WEST SUSSEX COUNTY COUNCIL CONSULTATION

TO:	Arun District Council - FAO: A Gardner
FROM:	WSCC - Highways Authority
DATE:	10 February 2021
LOCATION:	46a & 47 Pier Road and Land North of Clifton Road Littlehampton BN17 5LW
SUBJECT:	LU/3/21/DOC Approval of details reserved by condition imposed under ref LU/287/17/PL relating to Condition Nos 6 - Construction Management Plan and 13 - hard & soft landscaping.
RECOMMENDATION:	Modification

APPENDIX B – CONTRACTOR SITE PARKING / STORAGE AREA (DRG 003)

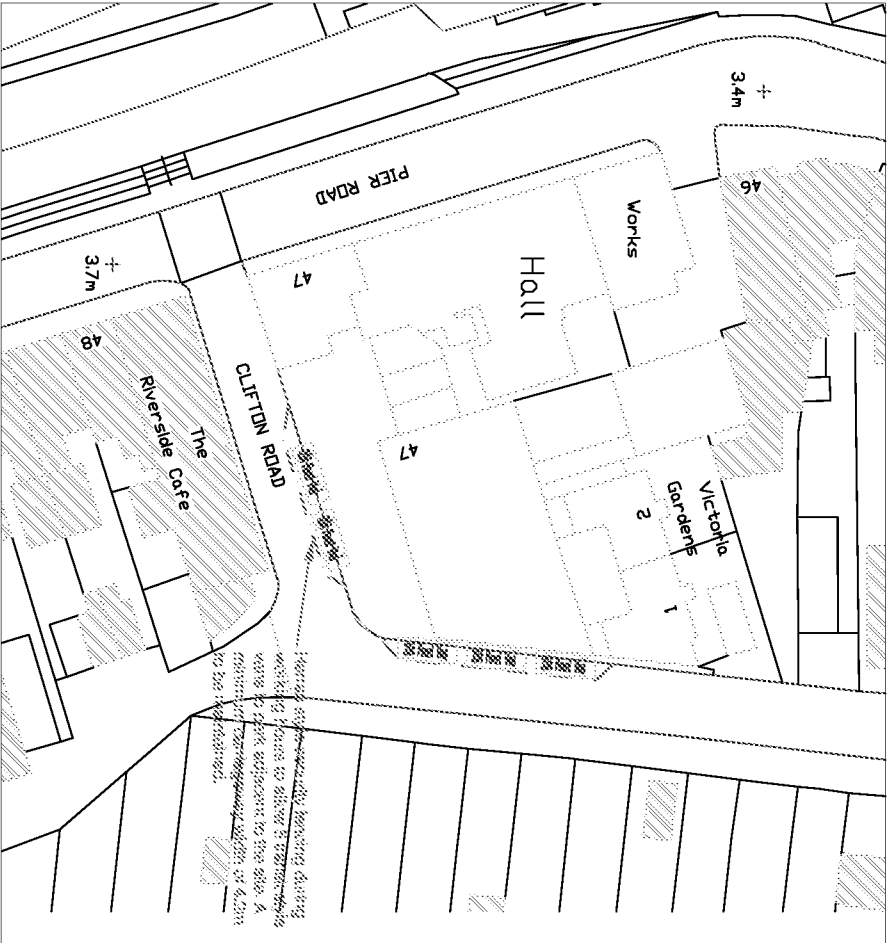
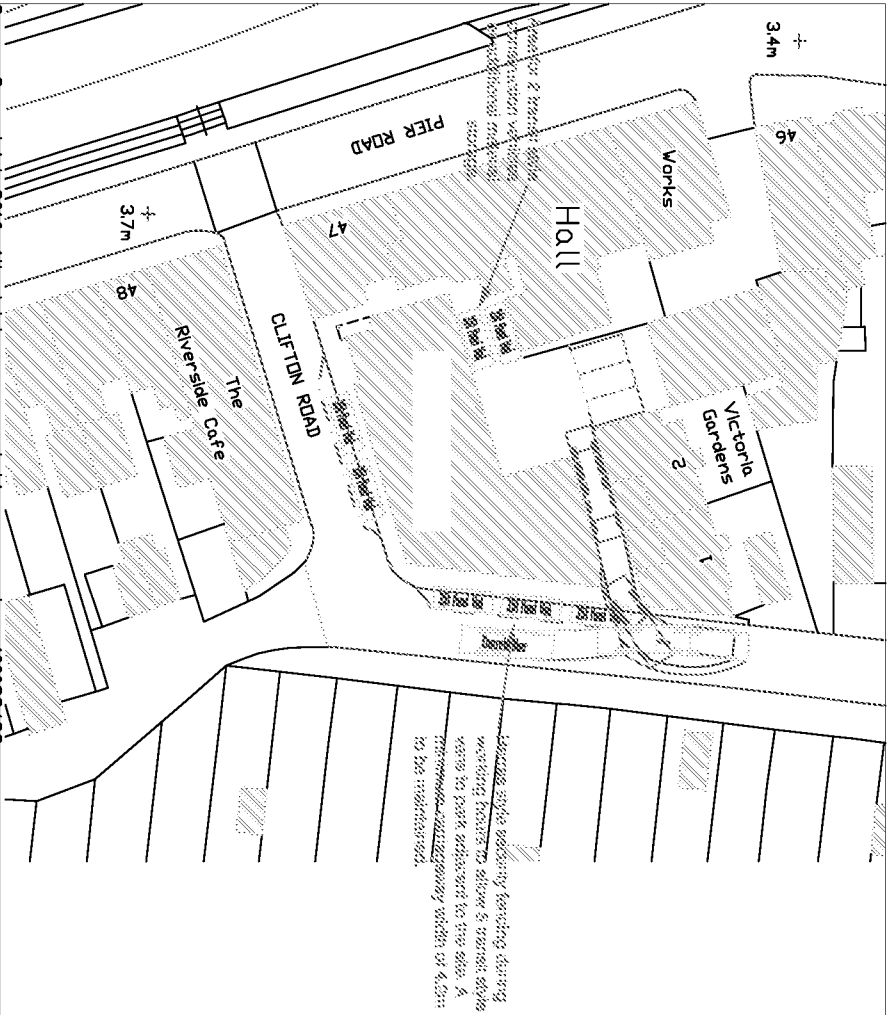
Some parking appears to be shown on Clifton Road adjacent south and east of site boundary. There are no waiting restrictions in this location and thus parking by contractors in this location should not be proposed and should be removed from the plans.

The loading and unloading of plant, materials and waste - smaller vehicles to be used where possible and banksman supervise manoeuvres on and off site. The plan appears to show larger vehicle will reverse in to the site in order to exit in a forward gear.

In summary the proposed contractor parking along Clifton Road should be removed. The applicant should also outline number of articulated deliveries expected and may wish to engage with Area Office at this stage to discuss any requirements for protecting pedestrians during deliveries.
